Application No: BR/13/22/HH
Site Address: 235 Hawthorn Road Bognor Regis PO21 2UW
Description of works: Erection of two storey side extension and single storey rear orangery following the demolition of existing rear conservatory and side extension.

Thank you for your internet representation made on 4th February 2022 which has been recorded as an objection with the comments as follows:

REAR ELEVATION PROPOSED 1:100

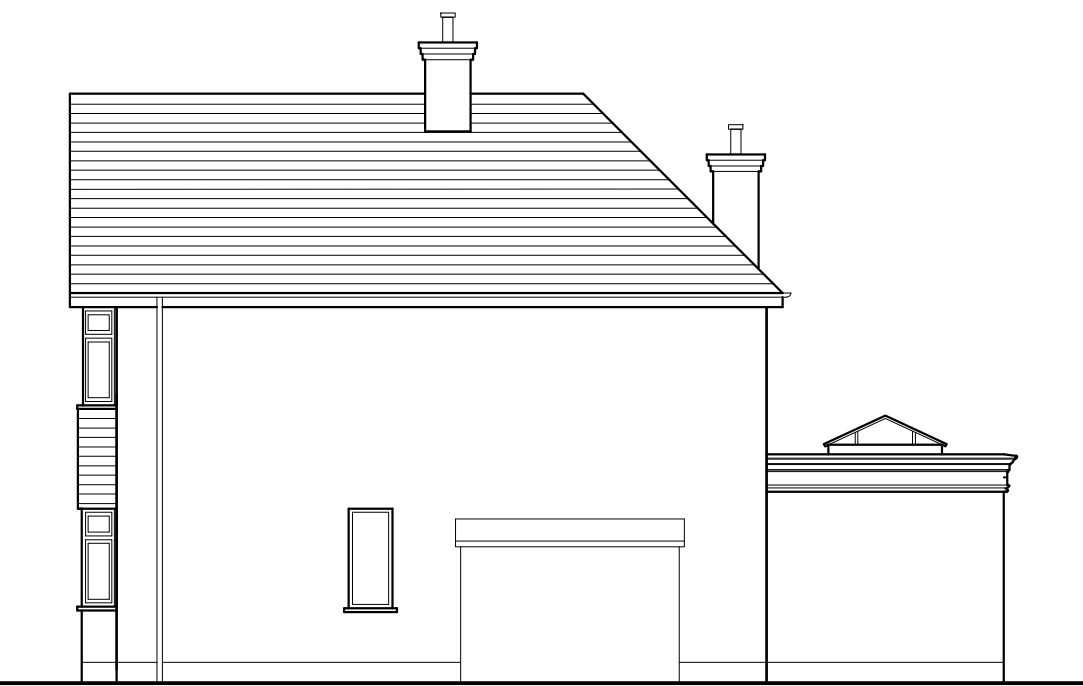
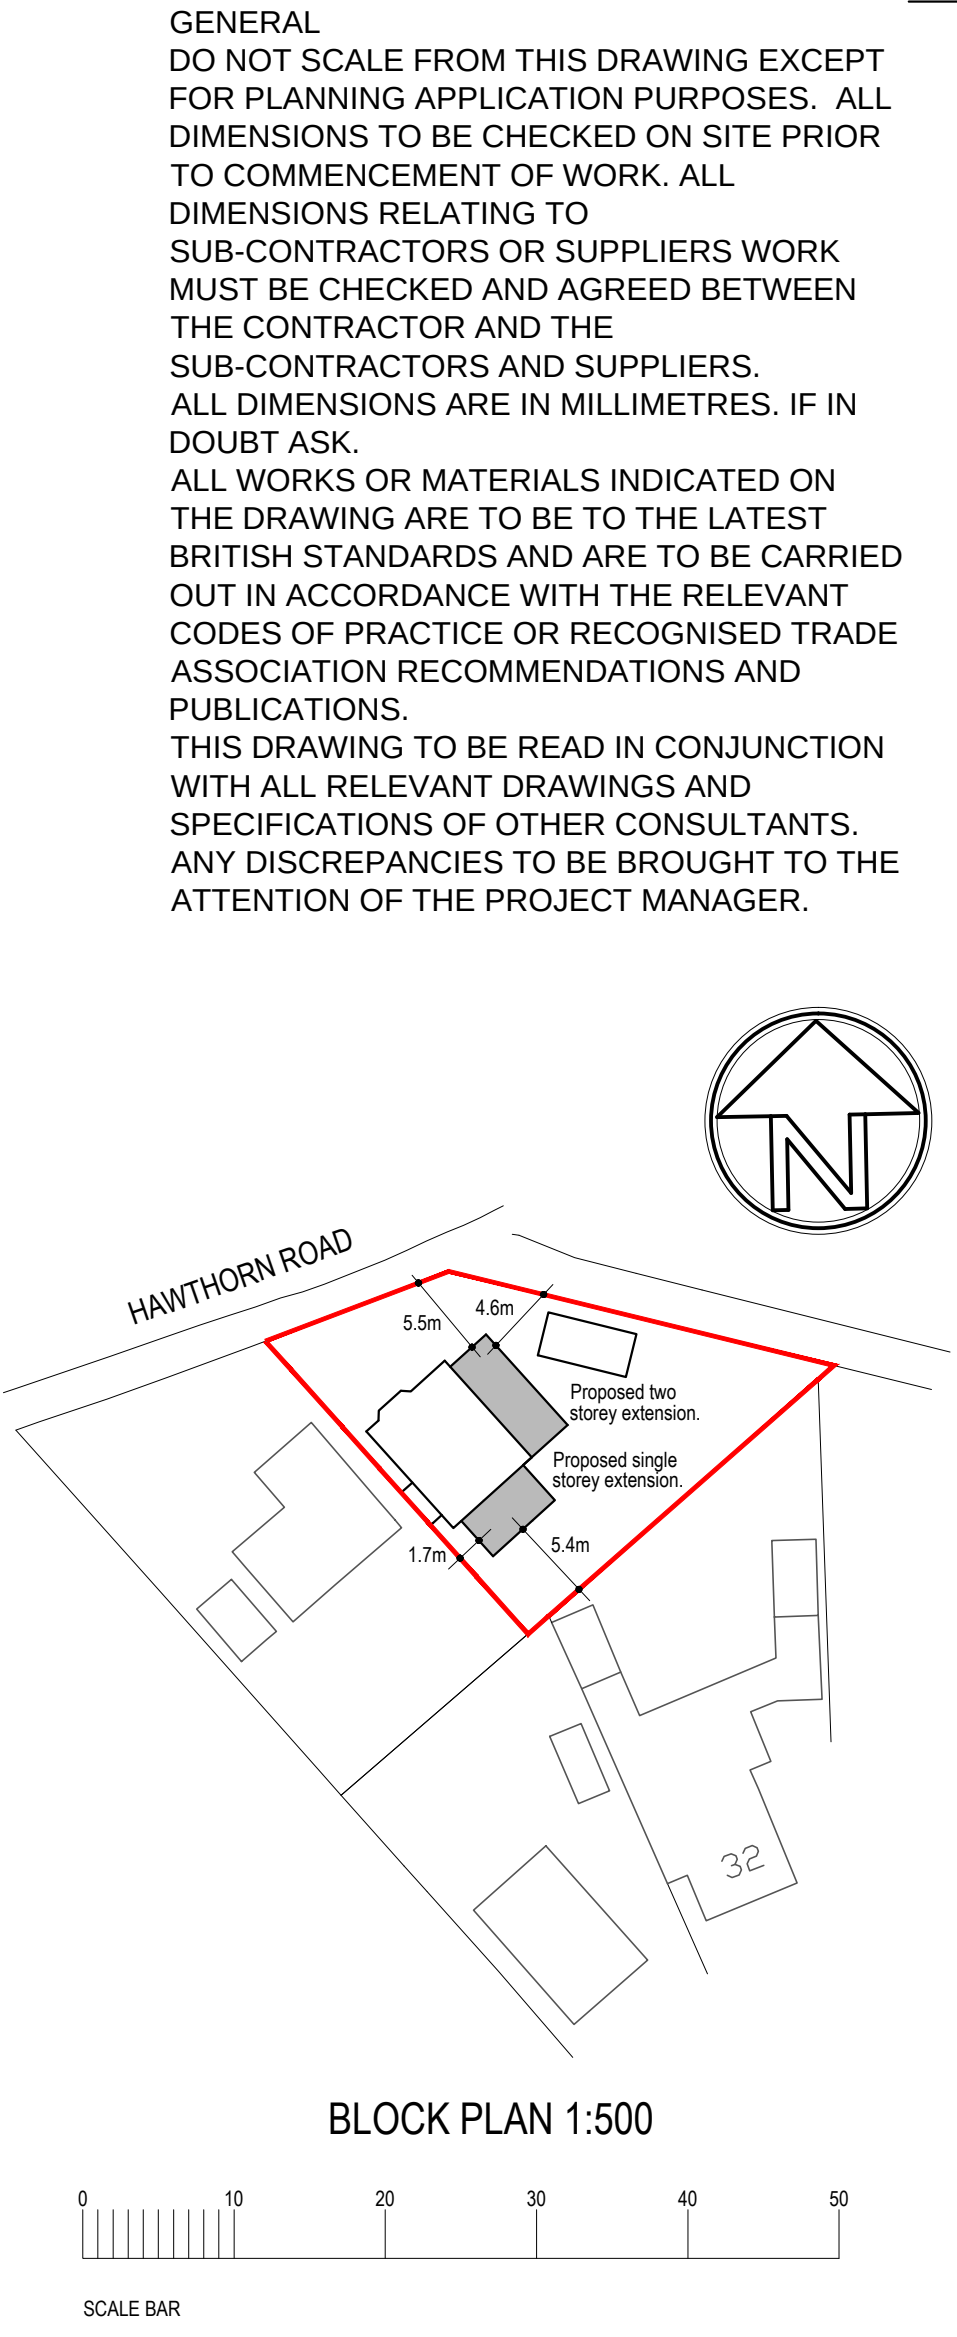
Due to the proposed house being situated on a fairly acute bend on Hawthorn road any windows on the rear of the property at a second story will permit a dual aspect view into multiple homes on Crescenta Walk. Whereas we have no effected impact from the proposed development in principle we do take extreme objection to the windows on the second story resulting in zero privacy for the kitchen/ family room and garden of our property and many others on Crescenta Walk.

Concern is raised to further concrete structures affecting what appears to be a fairly high water table already? I hope consideration can be taken in to the application in omitting the windows to the rear elevation on the second story.
